# PLANNING BOARD REPORT PORTLAND, MAINE

Residential townhouse - 6 unit condominium  
133 York Street  
Level III Site Plan and Subdivision  
Project ID 2013-187  
133 York, LLC, Applicant

Submitted to: Portland Planning Board Public Hearing Date: November 12 <sup>th</sup> , 2013	Prepared by: Jean Fraser, Planner Date: November 8 <sup>th</sup> , 2013 <b>Planning Board Report # 50-13</b>
---	--

**C1.0**

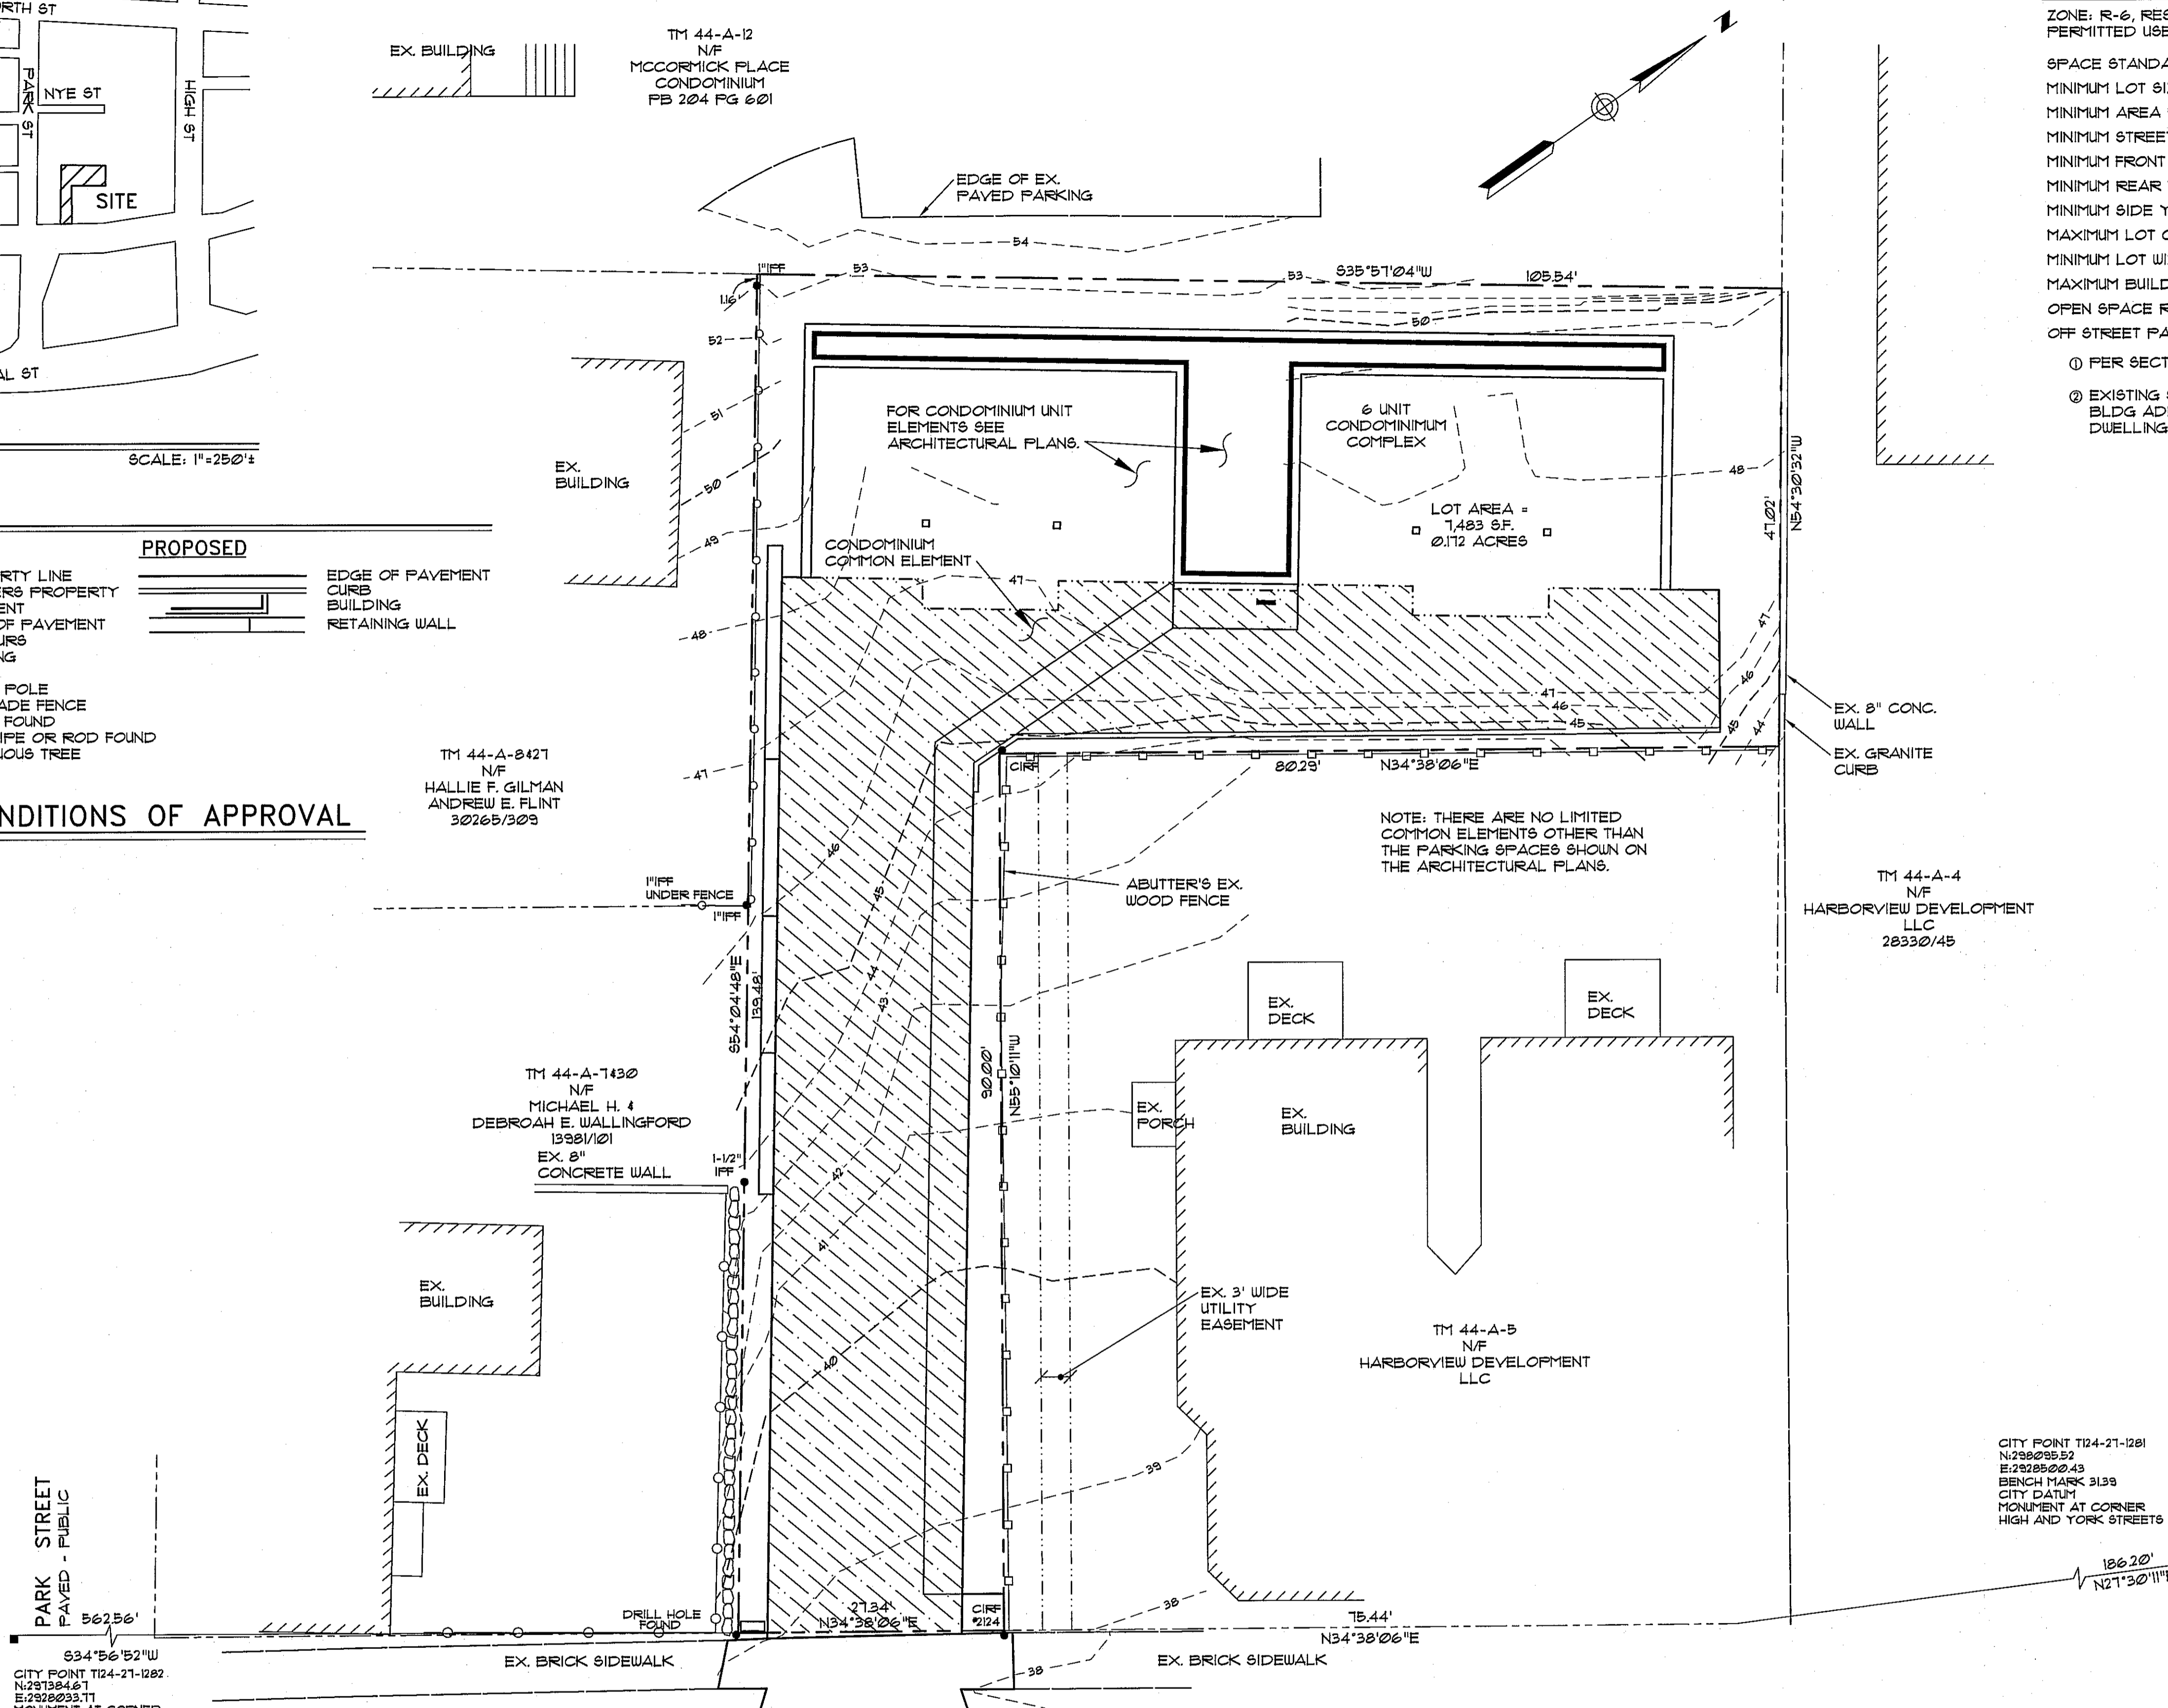
The application (Attachment B) refers to the fact that the site benefits from a sewer easement across the Harborview Flats property and this is not referenced on the Boundary Survey nor the draft Subdivision Plat.

The applicant has submitted a draft Subdivision Plat (Plan 2) and draft Condominium documents (Attachment D). The potential conditions of approval suggest amendments to both documents and further review by staff.

An “Off-Site Snow Removal Plan” is included on Plan 4 and staff consider this is acceptable. The importance of timely snow clearance was part of the Traffic Engineer comments (Attachment 14), so the “Snow Removal Plan” is suggested to be highlighted on the Condominium Association documents and on the Subdivision Plat.

- i. That the Subdivision Plat shall be finalized to the satisfaction of the Planning Authority, Corporation Counsel, and Department of Public Services and include detailed references to easements, snow removal, green wall maintenance, Condominium Association documents and relevant conditions; and

- v. That the applicant shall add a note on the Subdivision Plat that the Condominium Association shall be responsible for the maintenance of the green wall, both the structure and the planting, and that any damage from vehicles backing into green wall shall be repaired within one week; and

- vi. That the Subdivision Plat shall include a note confirming the Snow Removal Plan details and that the Condominium Association is responsible for this being undertaken in a timely fashion.
